CITY OF ALBUQUERQUE

July 17, 2017

**Re: Glendesto Subdivision
Erosion and Sediment Control Plan
Engineer's Stamp Date 7-7-17 (B18E020)**

SILT FENCE FOR SEDIMENT CONTROL

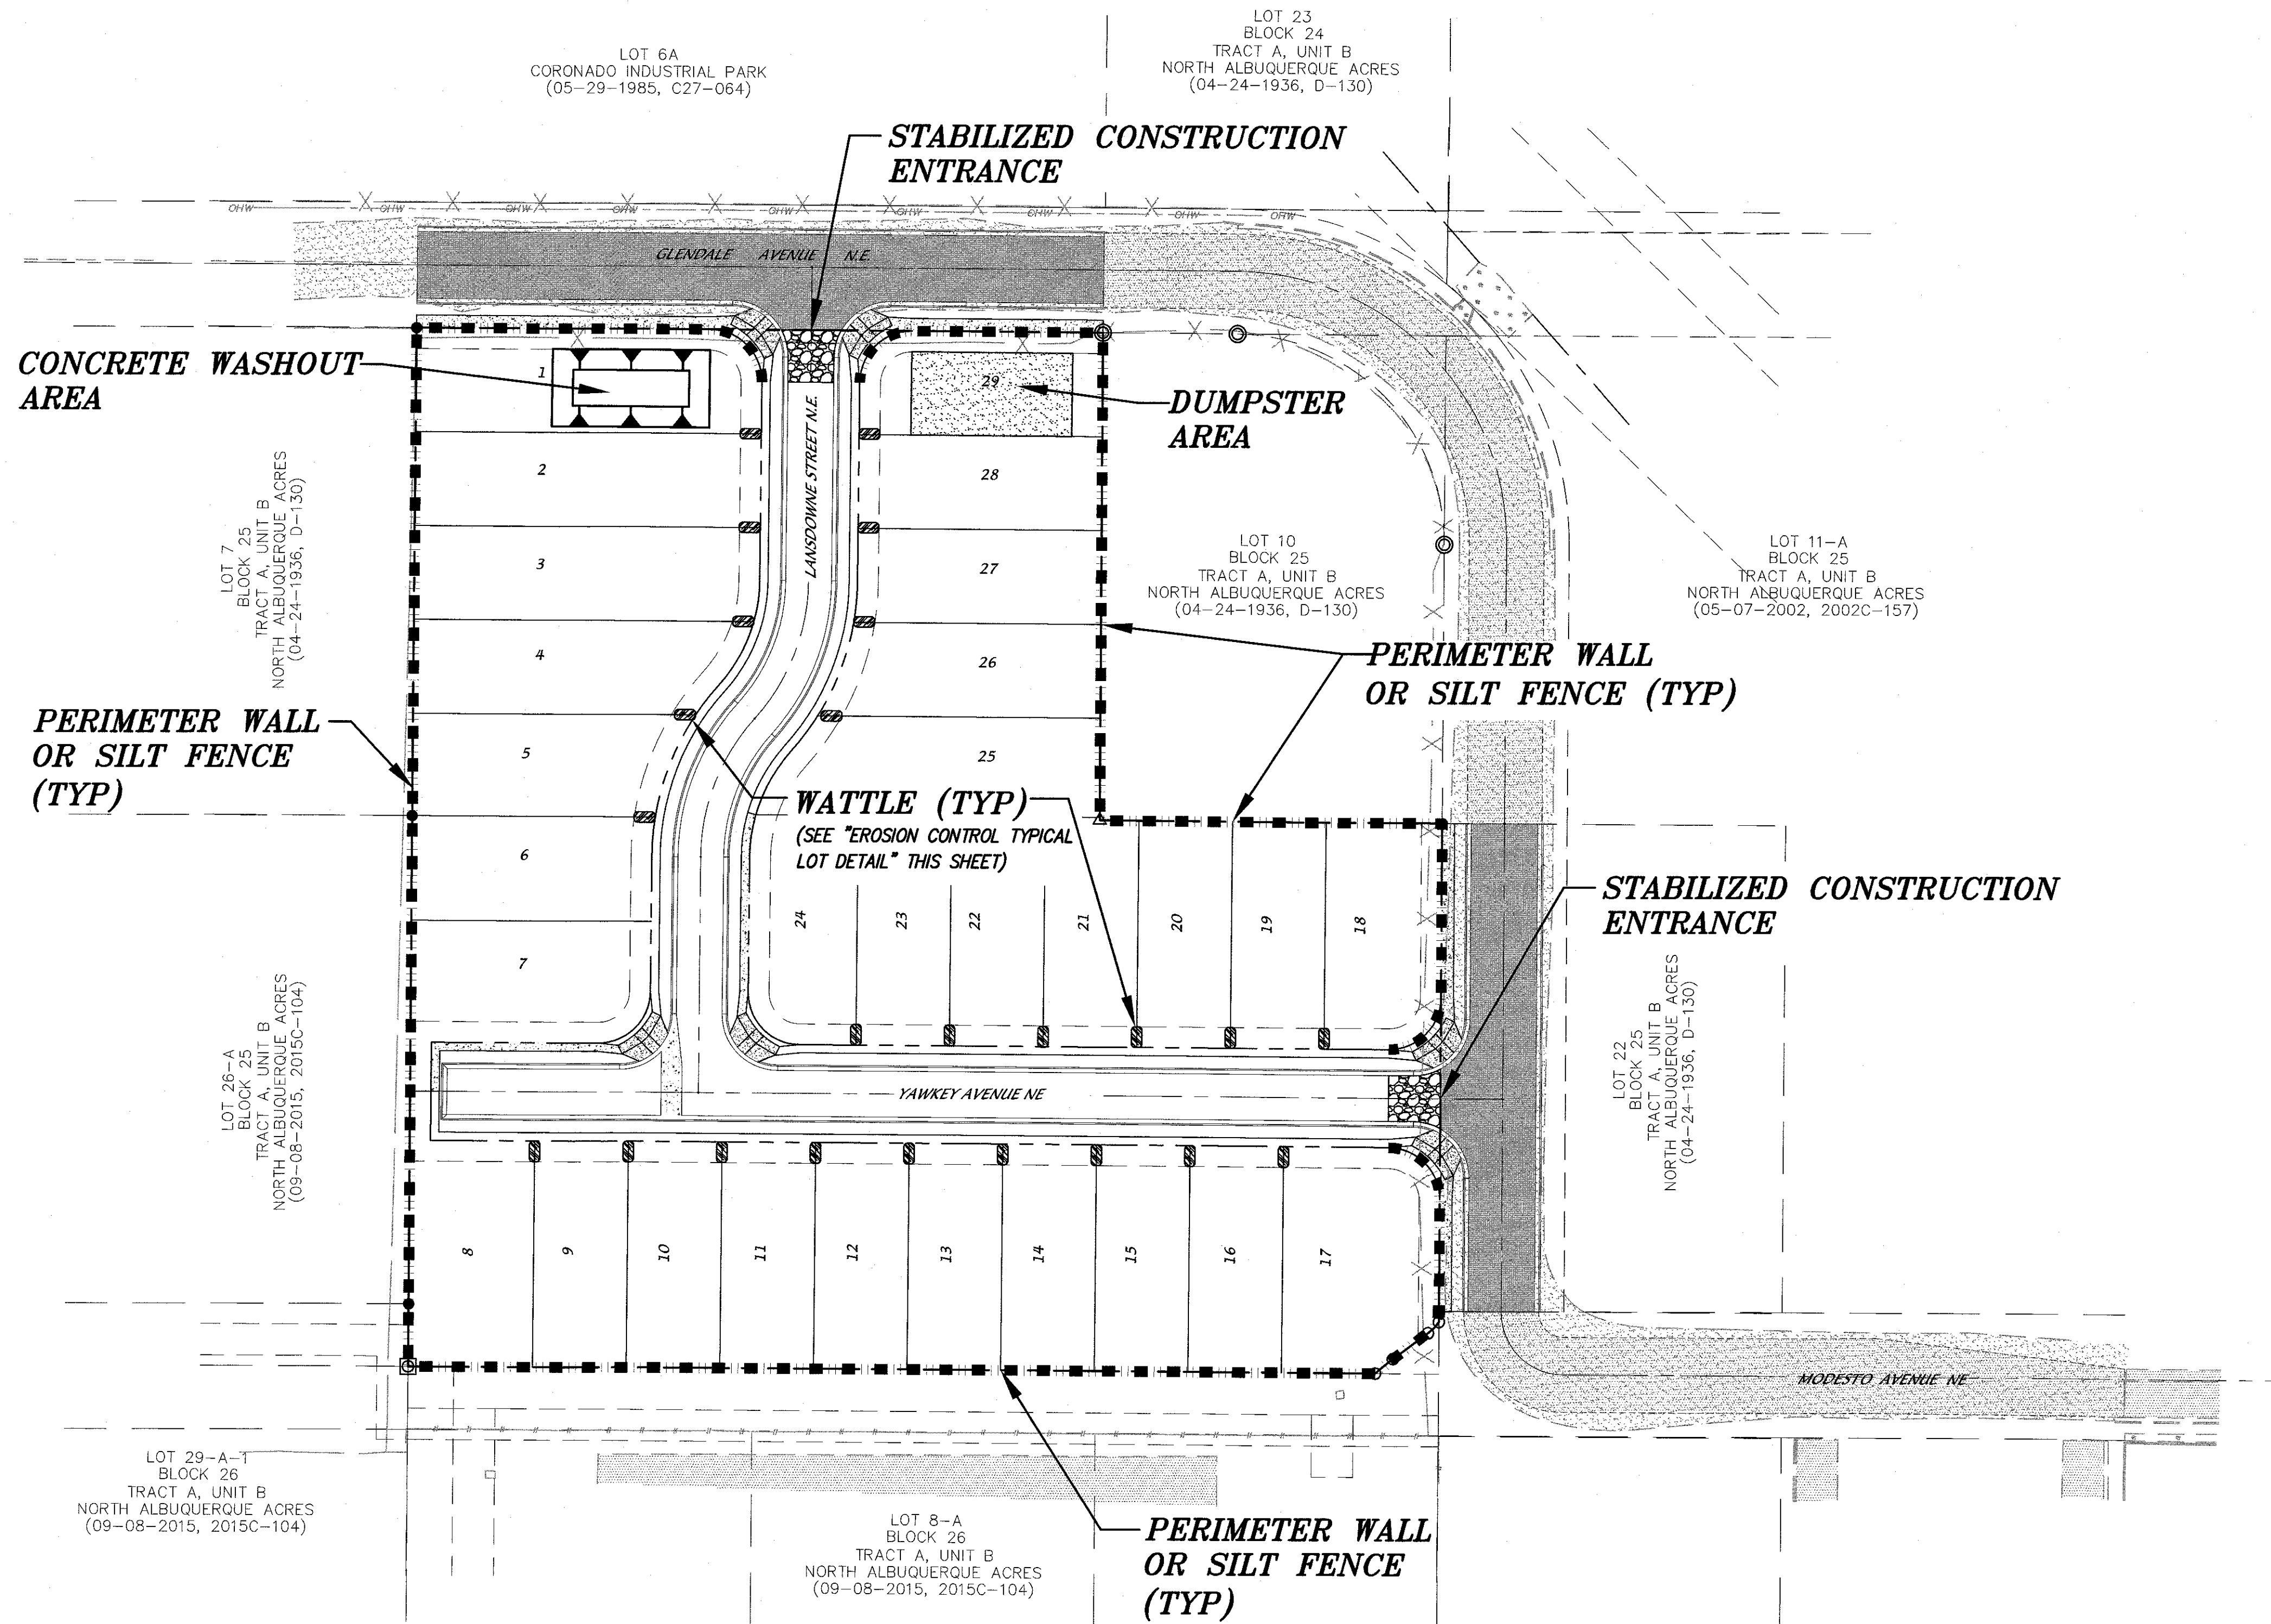
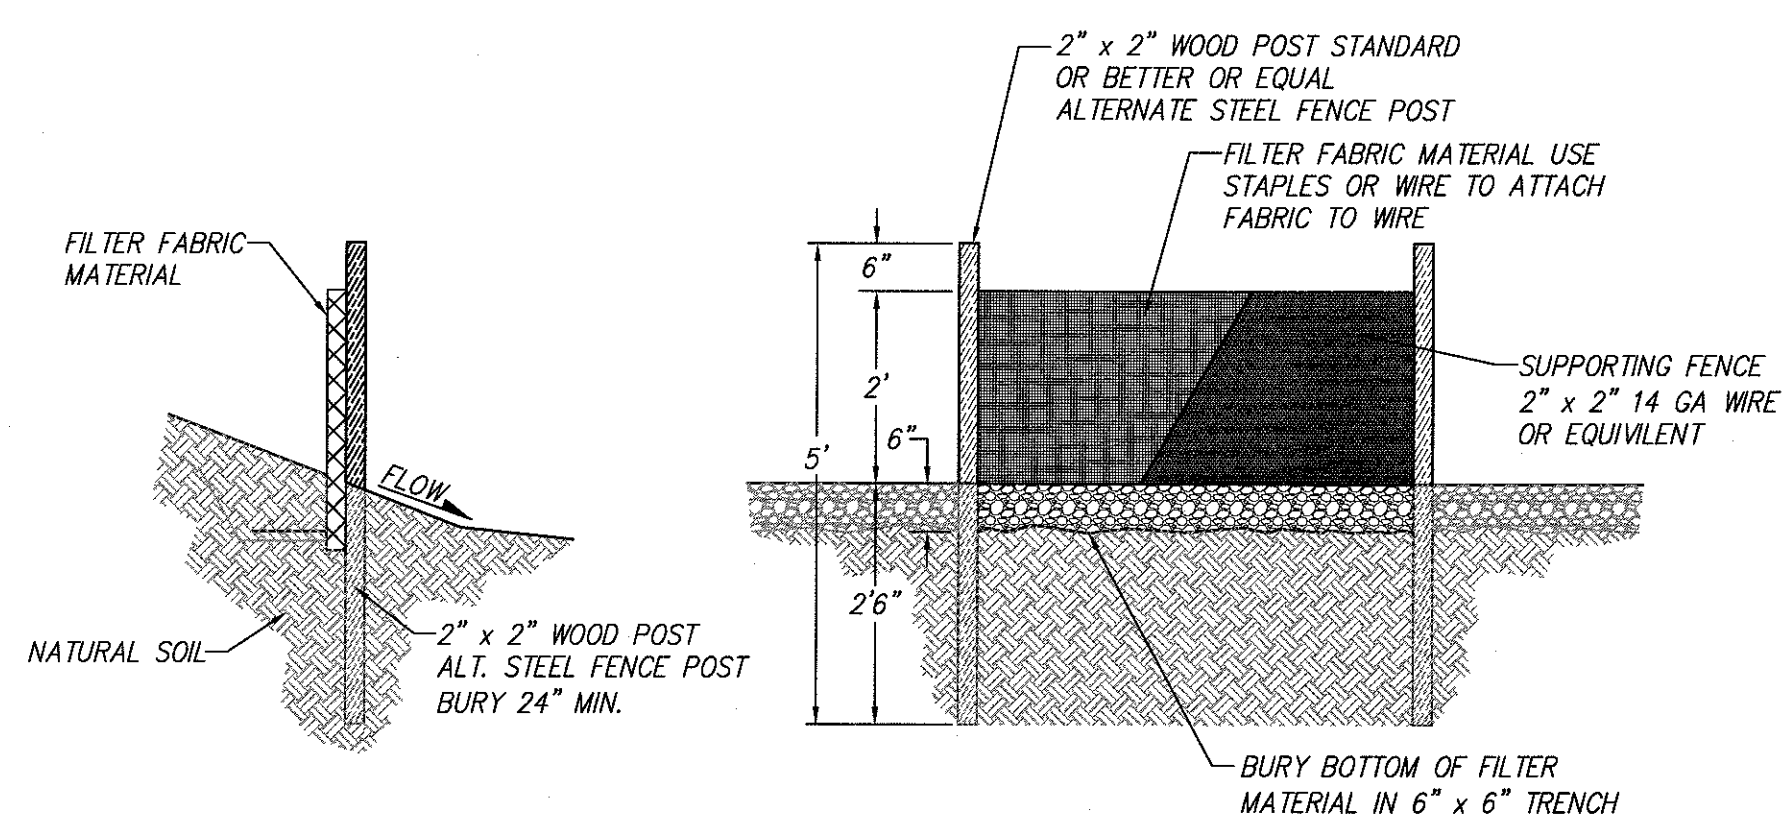
1. Provide a maximum pole spacing on the silt fence detail. For most areas, 10 feet max between poles is acceptable, but at an outfall location, the spacing should be closer to 6 feet max.
2. Show the outfall location.
3. Revise General Note #1 to : "When doing work in the City ROW (e.g. sidewalk, drive pads, utilities, etc...) prevent dirt from getting into the street. If dirt is present in the street, the street should be swept at the end of each day or during the day if rain is imminent or if the contractor introduces water into the street.
